Our ref: P00493396
25 January 2016

**Arrangements for Handling Heritage Applications Direction 2015 &
T&CP (Development Management Procedure) (England) Order 2015**

**CHURCH NORTON SPIT, PAGHAM BEACH, PAGHAM PO21 4NJ
Application No P/97/15/PL**

Block Plan Showing the Proposed Compensation Area ('New Tern Island')

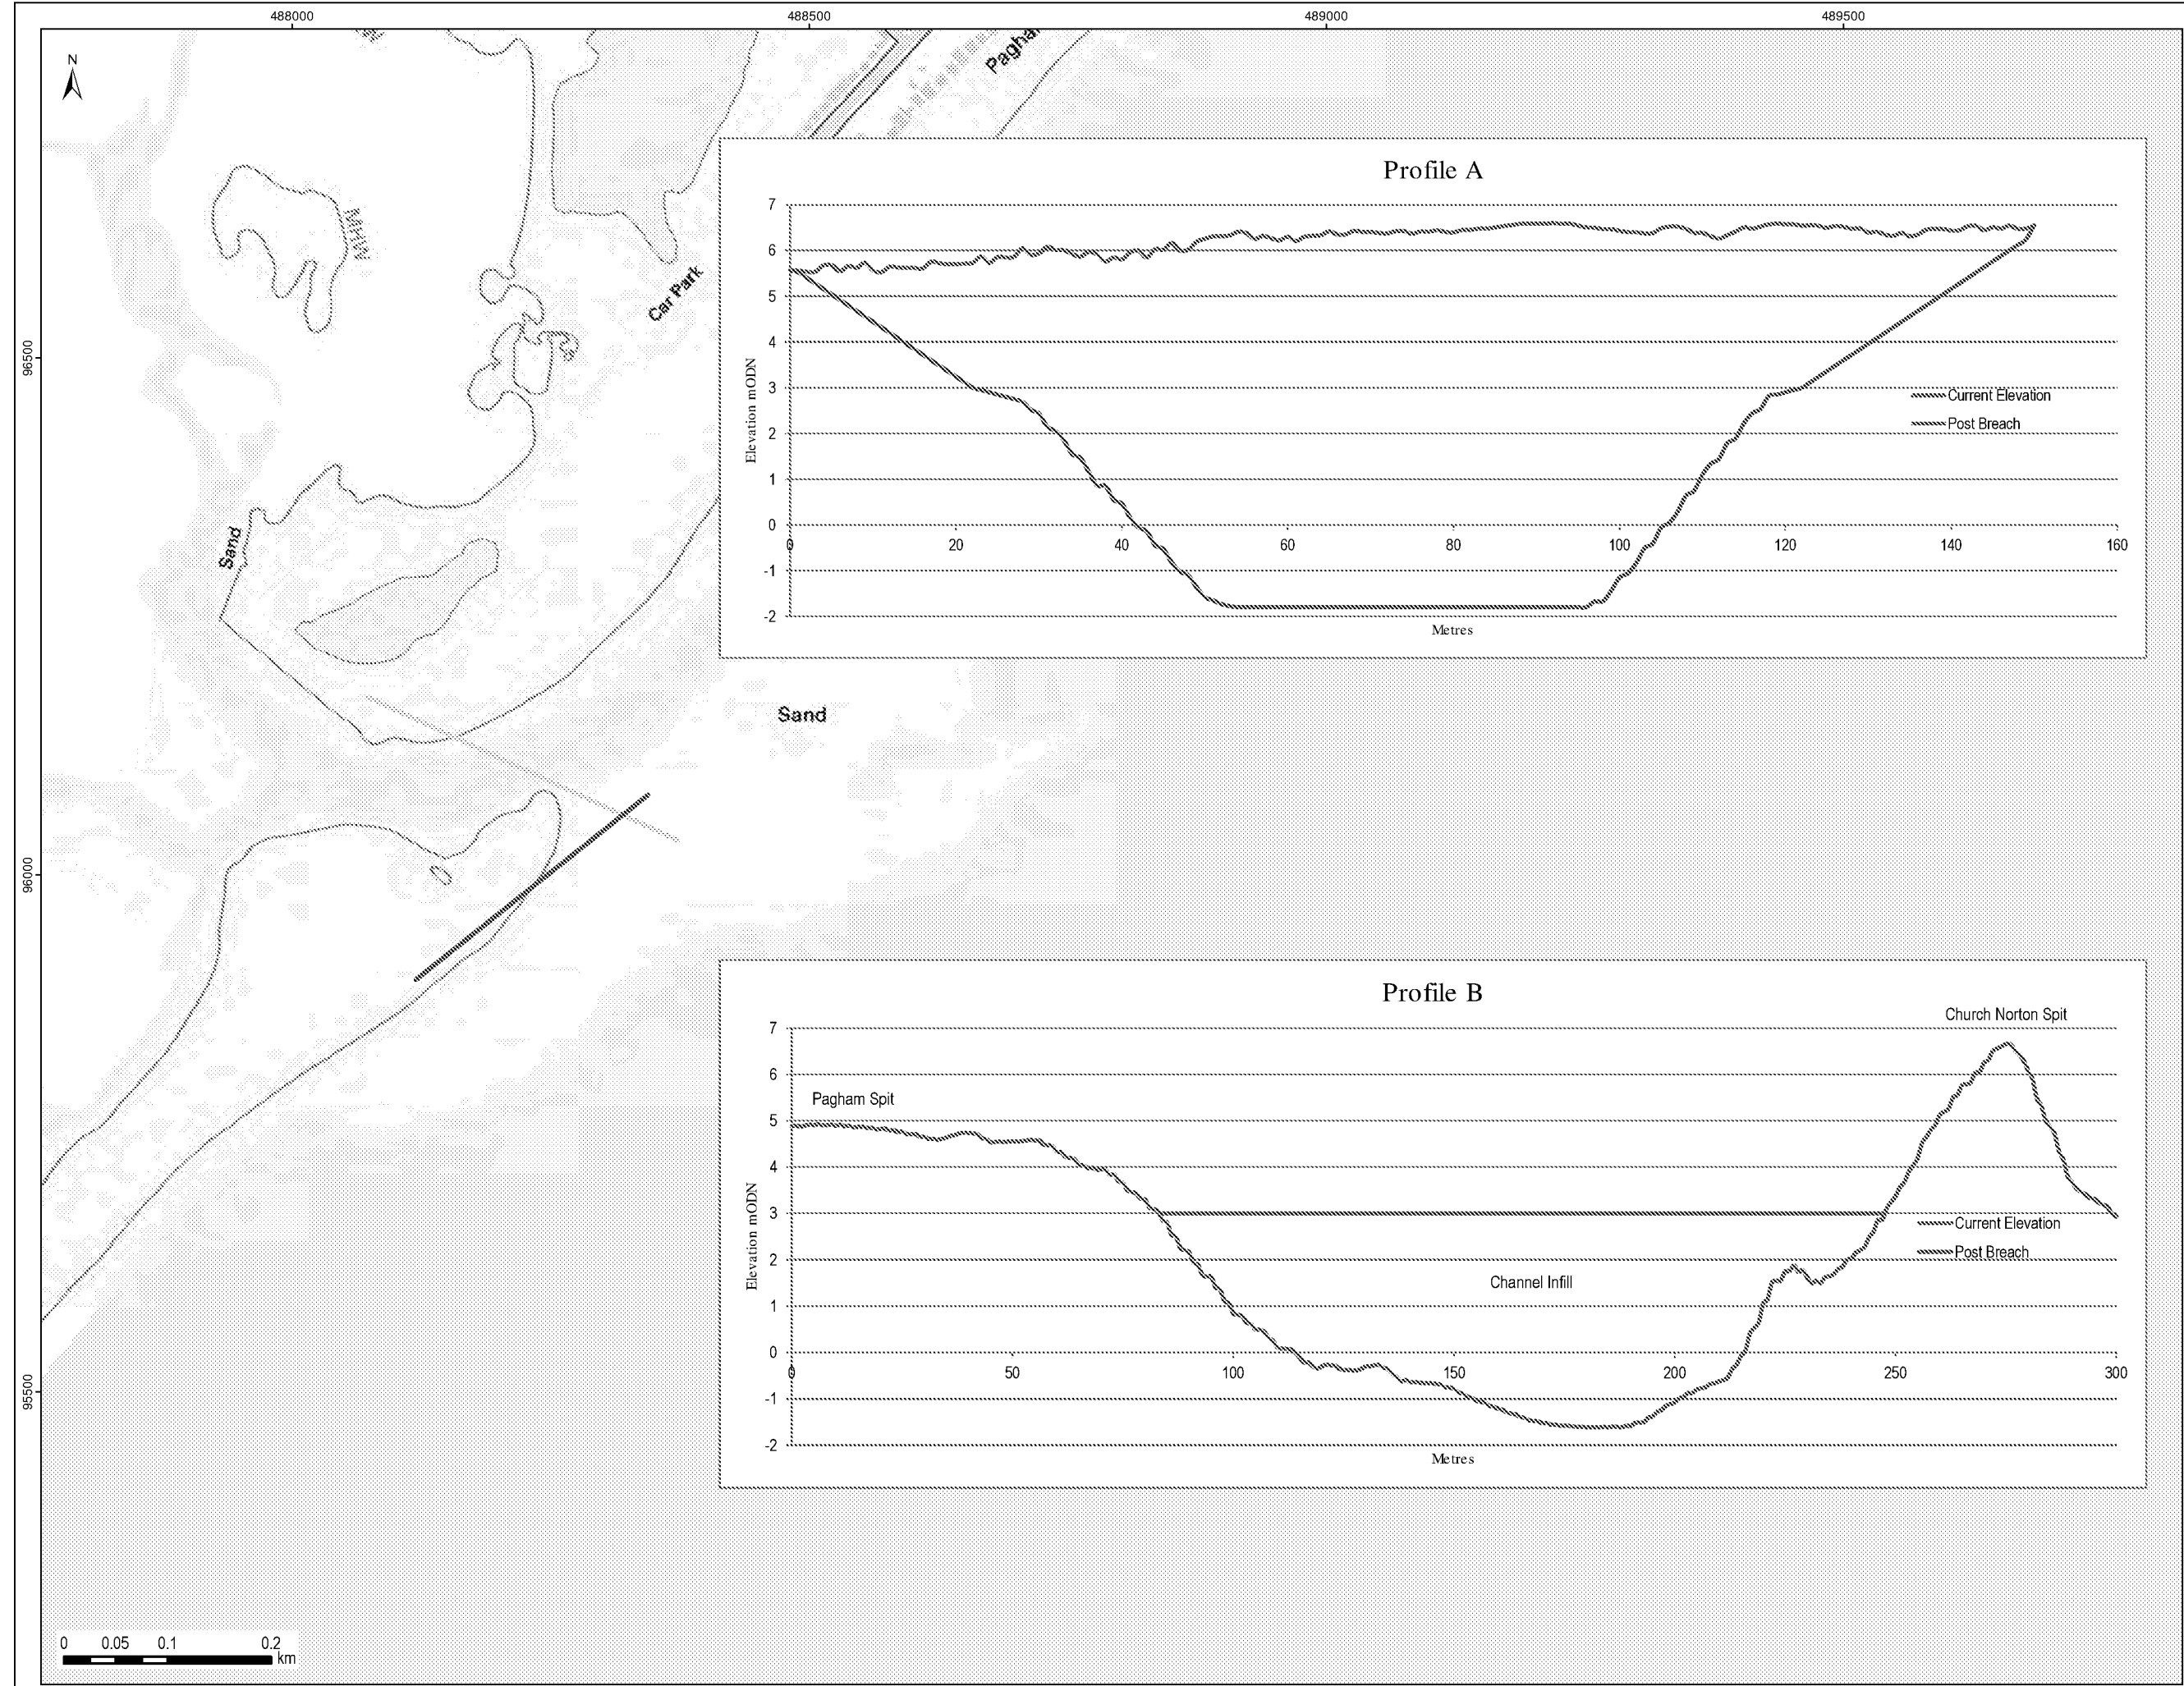
The ES also mentions the creation of a new island for Little Terns (as compensation for possible loss of habitat). This will be in the area of a concrete structure (EIA 11.2.2, p 249), which will be covered with shingle from the breach to protect the structure, and will be cut off from the spit by a channel, which will isolate the new island from predation. No information has been supplied indicating what the concrete structure is, but we note that concrete structures are often heritage assets linked to military defence of the coastline, particularly during WWII. Creation of a channel might also impact on harbour deposits of as yet uncertain archaeological potential.

[1] No development shall take place until the developer has produced a desk based assessment detailing the heritage significance of the development area and potential impacts of development on the historic environment, and following this; has secured the implementation of a program of archaeological investigation and mitigation (to include terrestrial archaeological, geoarchaeological, and marine field archaeological work as appropriate), undertaken in accordance with a Written Scheme of Investigation, which has been submitted to and approved in writing by the Local Planning Authority as advised by Historic England and the Chichester Archaeological Officer.
